**PREFERRED PROJECT REPORT
MP 10_0058**

LOTS 101 & 102, 52-58 WALKER STREET, RHODES

SEPTEMBER 2010

**Figure 7a: Recommended *Minimum* Tree Planting Layout for the Ground Level**

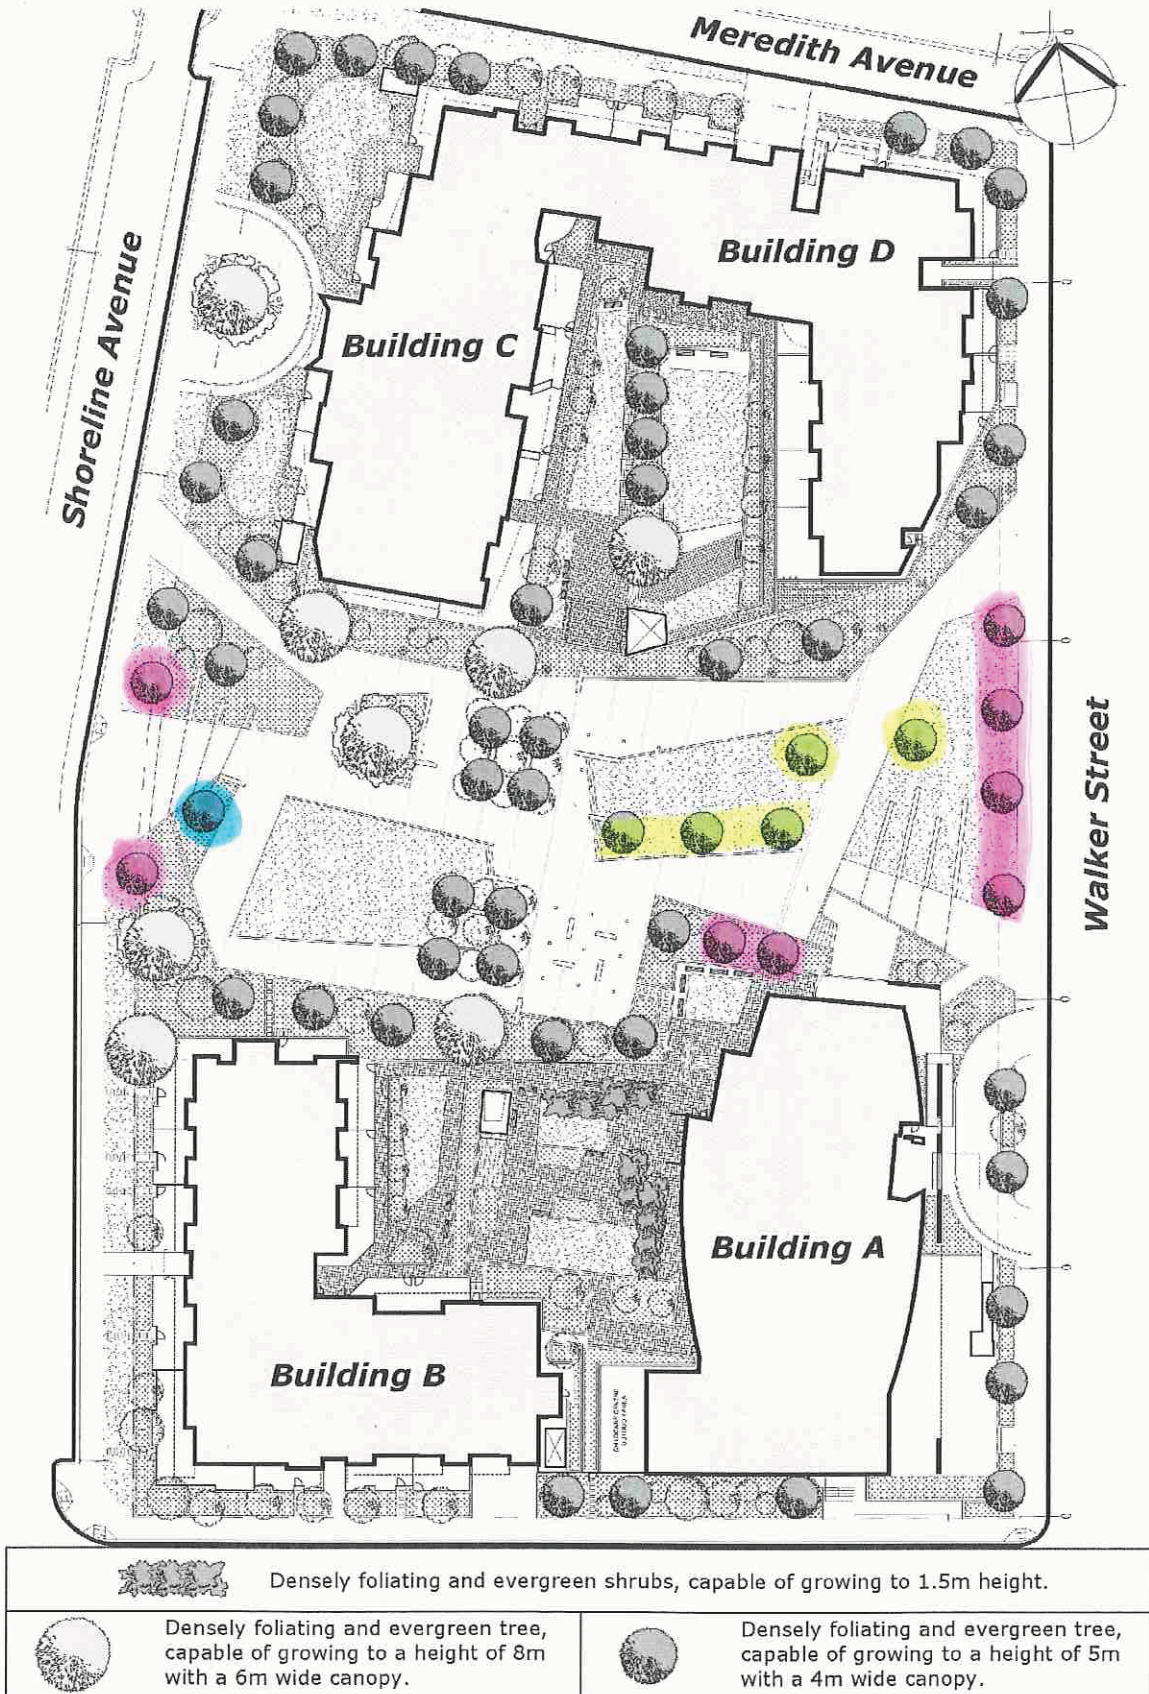
The proposed trees that were identified on the wind environment study for the Walker Street end of the public park gave no consideration to the fact that the approved public domain plan for the Precinct contains street trees. The approved street trees will provide the function intended by the tree locations in the wind environment report.

The location of trees as recommended in the wind environment study has been reconsidered and incorporated, where appropriate, in the redesign of the landscaped area. The amended landscape plan is at **Annexure 4**.

Meriton's landscape design consultants, Site Image, have incorporated trees onto the site where deep soil is to be provided or where appropriate soil depth over podium can be achieved in order to host the identified trees.

PRELIMINARY
 LANDSCAPE PLAN
 Scale: 1:200 @ B1
 Drawing Number: 101 E

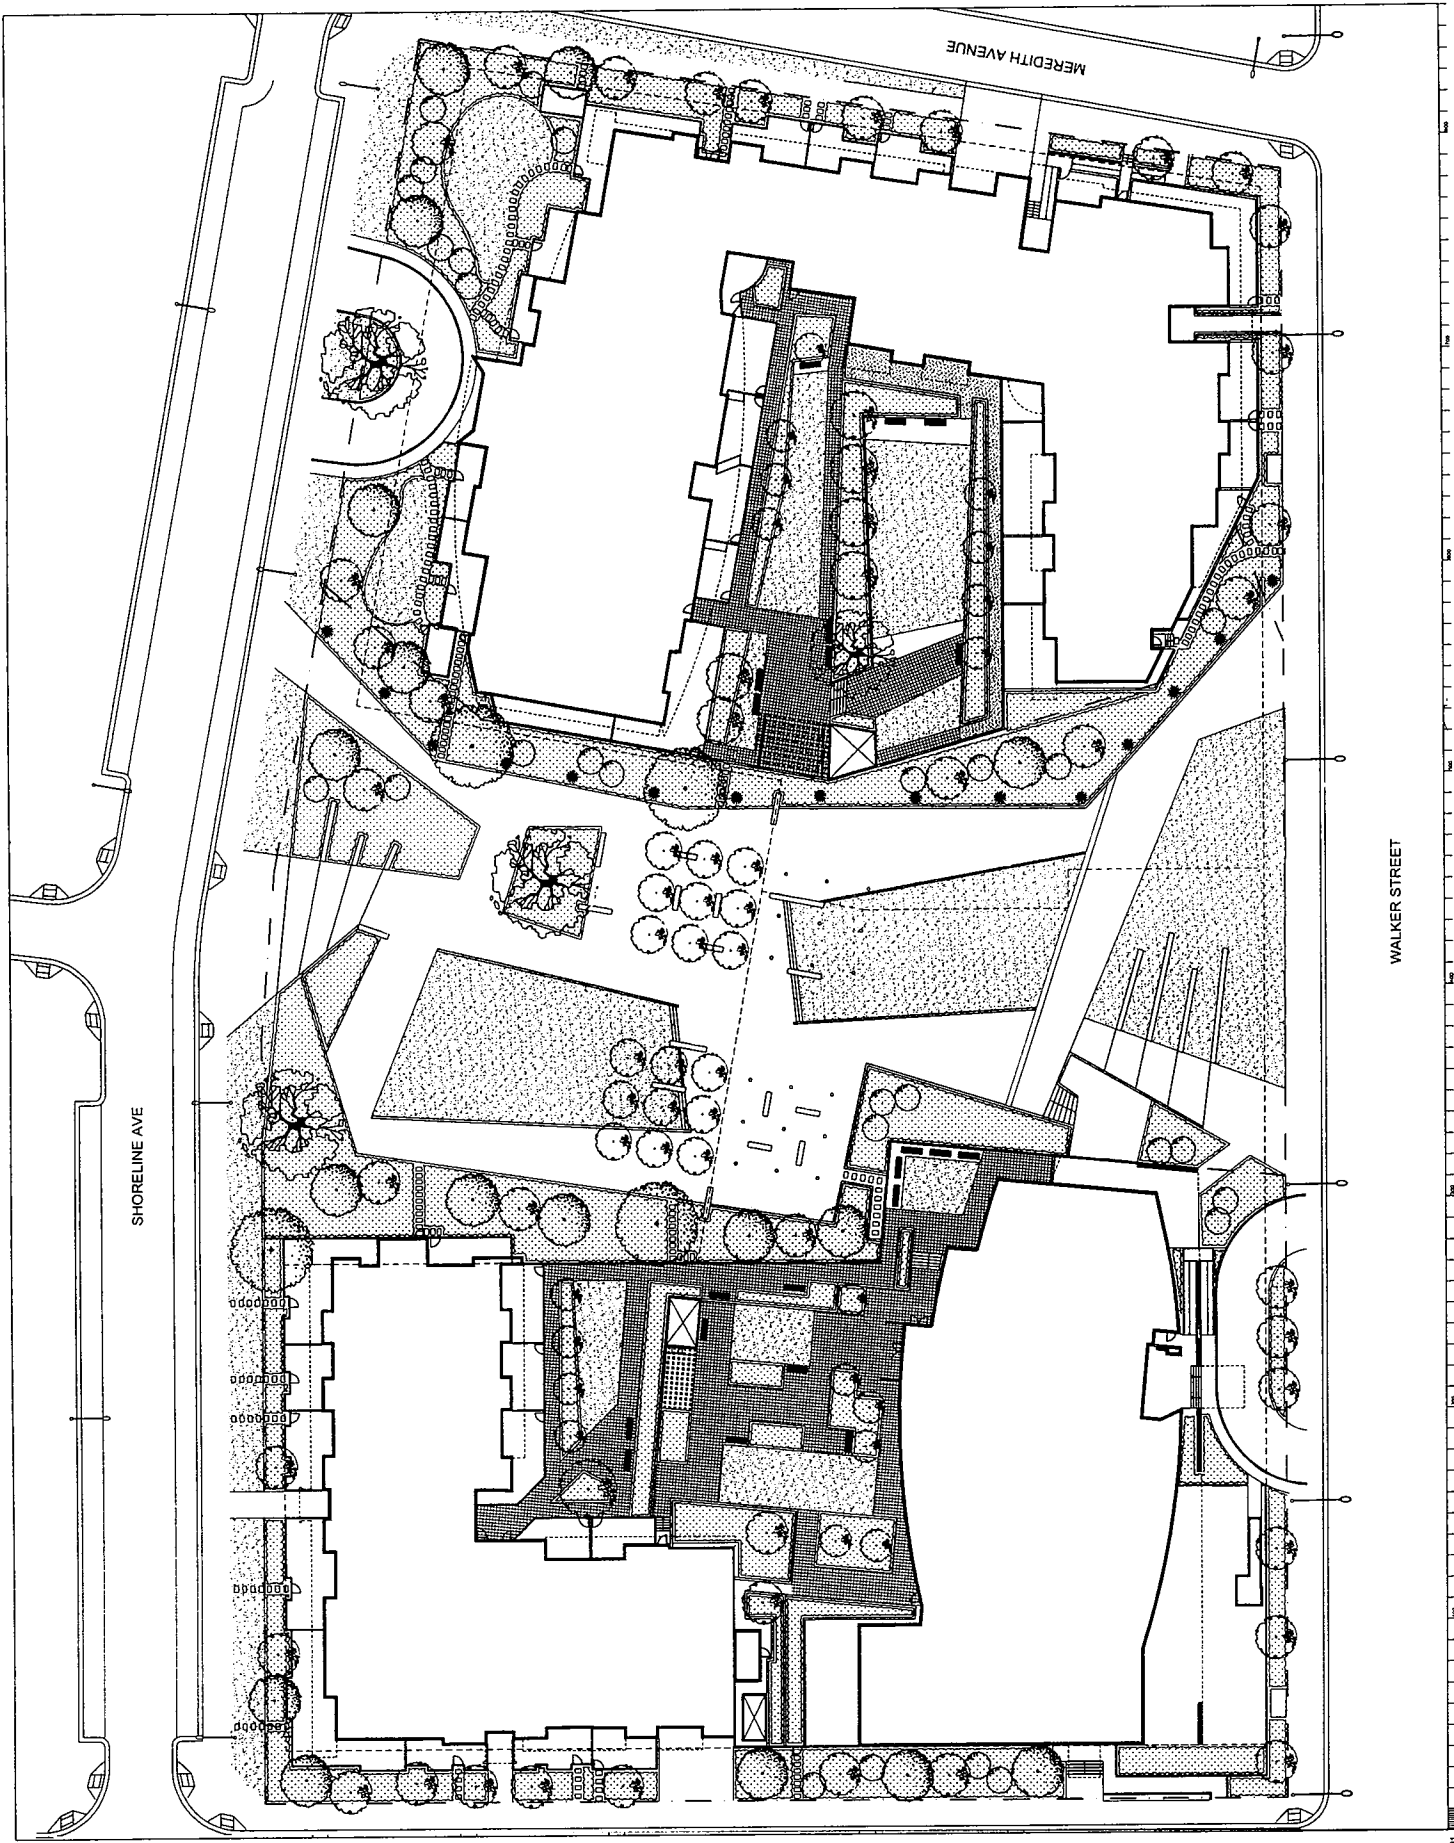
The landscape for the public park has been redesigned to provide for the 'three-room' concept promoted by John Toon. Details are provided at section 3.3 of this report.

The interface between the public park and the proposed development has been redesigned by Meriton's landscape consultants. The amended landscape plans at **Annexure 4** show that additional mounding and/or terracing has been incorporated into the interface area to ensure an improved visual transition.

The substantial hard paved areas have been removed from the public park and much more emphasis has been placed in providing soft landscaping.

"ADAPTED UNIT"
BLOCK B: G14,111,114

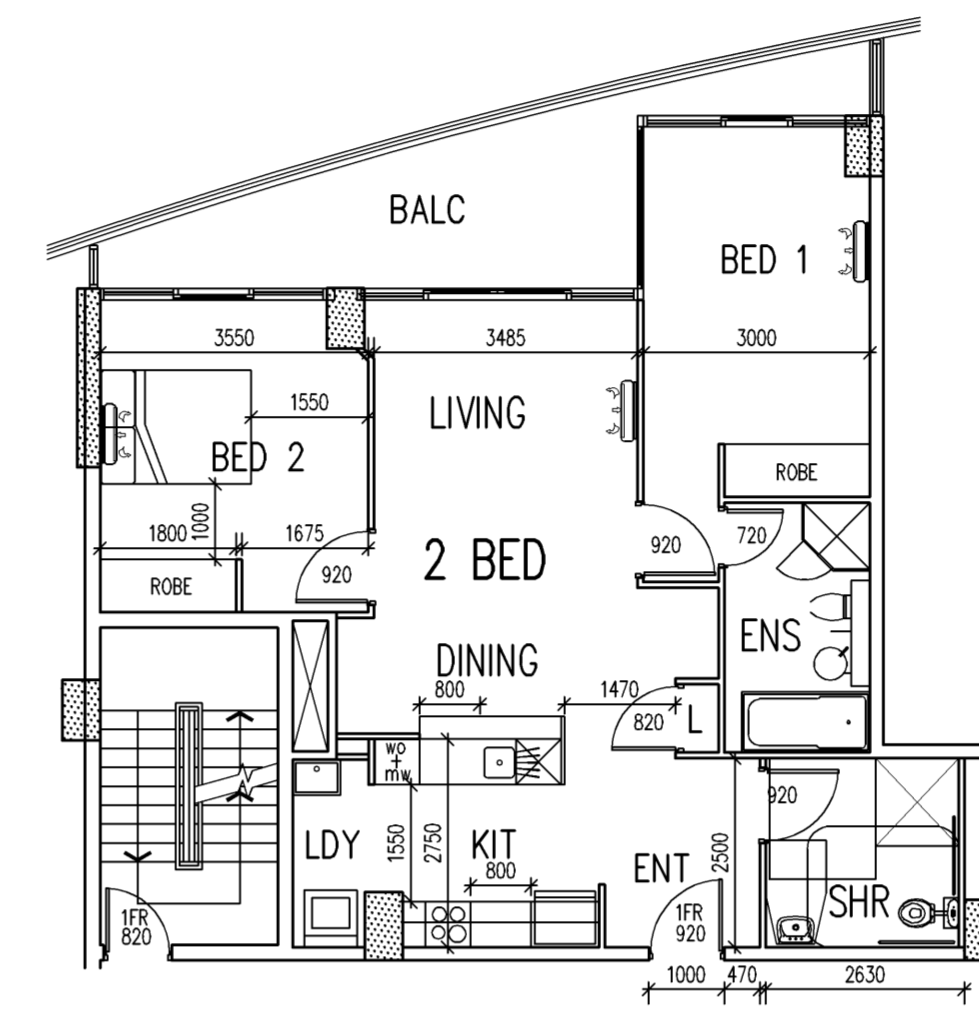
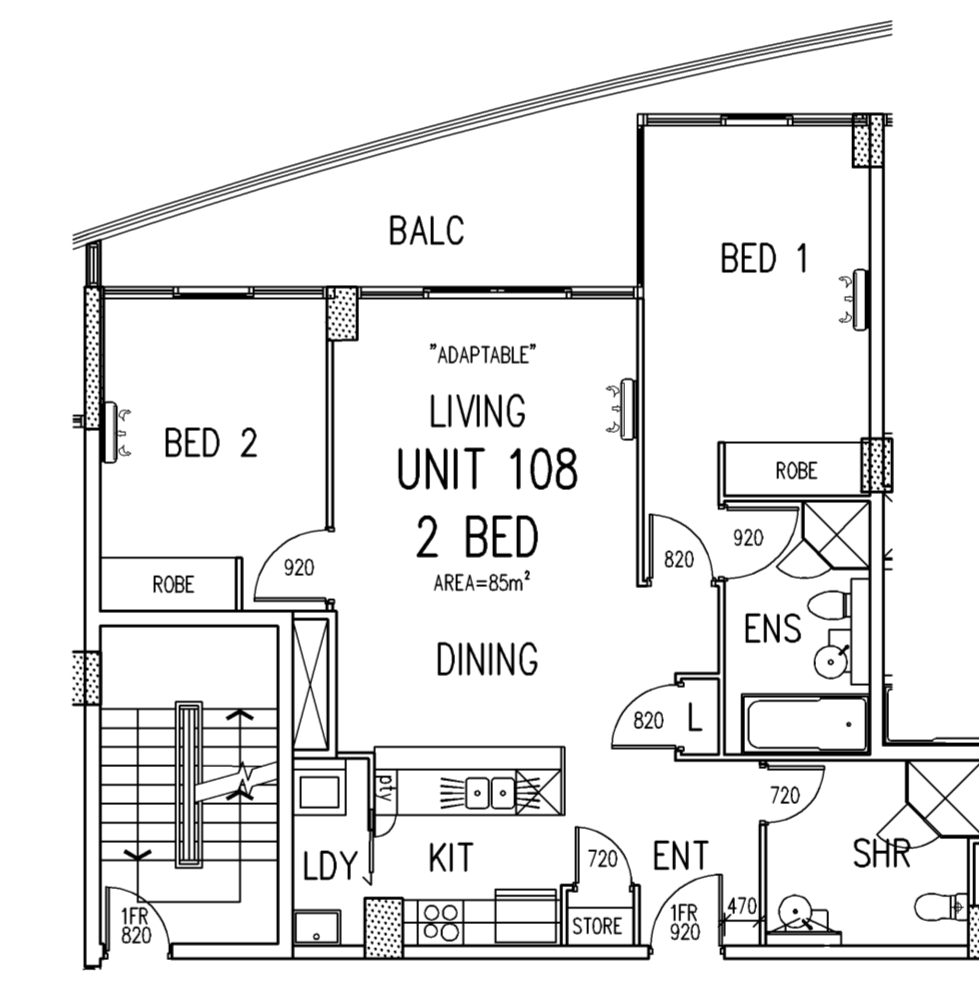
The proposal has been amended to ensure that 15% of the apartments are adaptable. One disabled parking space has been provided in the basement for each adaptable dwelling. The amended architectural drawings are at **Annexure 3**.
